WEST SUSSEX COUNTY COUNCIL CONSULTATION

TO:	<u>Arun</u> District Council <u>FAO:</u> Michael Eastham
FROM:	<u>WSSC</u> - Highway Authority: Tim Townsend
DATE:	13 August 2020
LOCATION:	Land at Angels Nursery <u>Yapton</u> Road <u>Barnham</u> <u>PO22 0AY</u>
SUBJECT:	<u>BN/84/20/PL</u> Application for variation of condition 2 (<u>approved</u> plans) imposed on planning permission BN/93/19/PL for the development of 95 dwellings; and consequential changes to other conditions following commencement of development.
DATE OF SITE VISIT:	<u>n/a</u> for purposes of this application (site visited previously)
RECOMMENDATION:	More Information Required and Modification
S106 CONTRIBUTION TOTAL:	SEE S106 FOR OUTLINE PROPOSAL

Comments below specifically respond to site layout details shown on 'Site Layout' drawing P19-0723-10 Revision 'N' dated 16th July 2020 produced by Pegasus Design. Should the case officer consider that there are further matters in this proposal needing consideration by the CHA, he should notify the author of this report at the earliest time.

PLOTS: [40, 41H, 42, 43H]; [44, 45, 46H]; [85, 86H, 87, 88H]

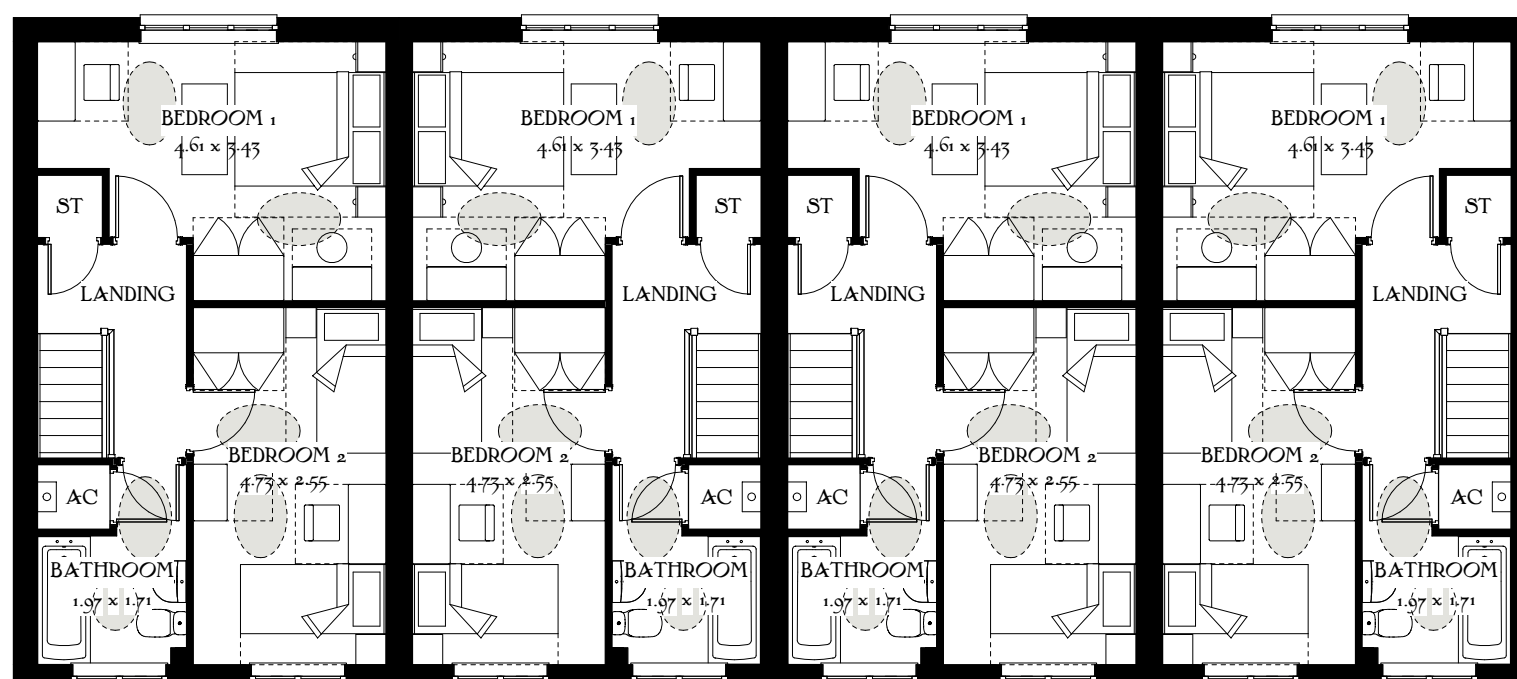
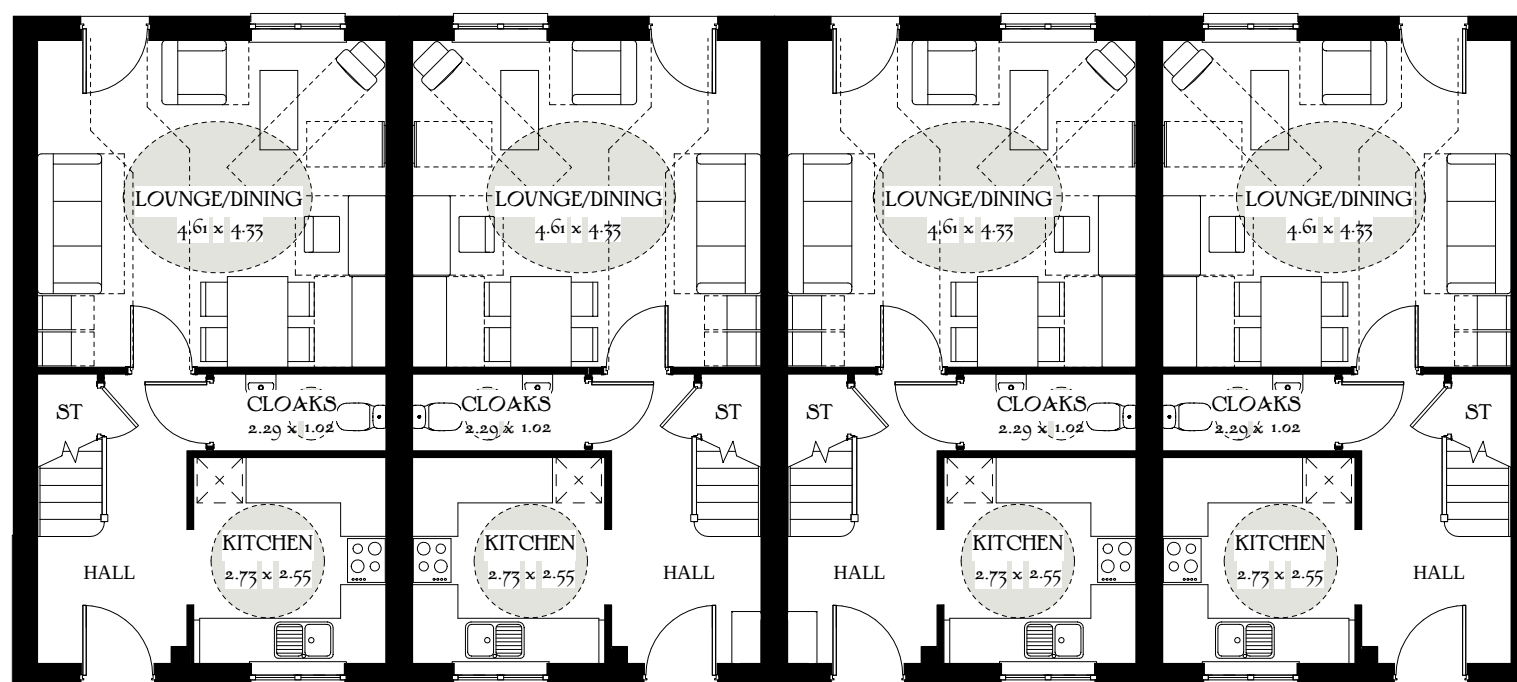
13. Pedestrian access is poorly shown to plots 40-43, 44-46 and 85-88. Please shown minimum 1.2m wide paths to access these properties from adjacent roadways/private drives.
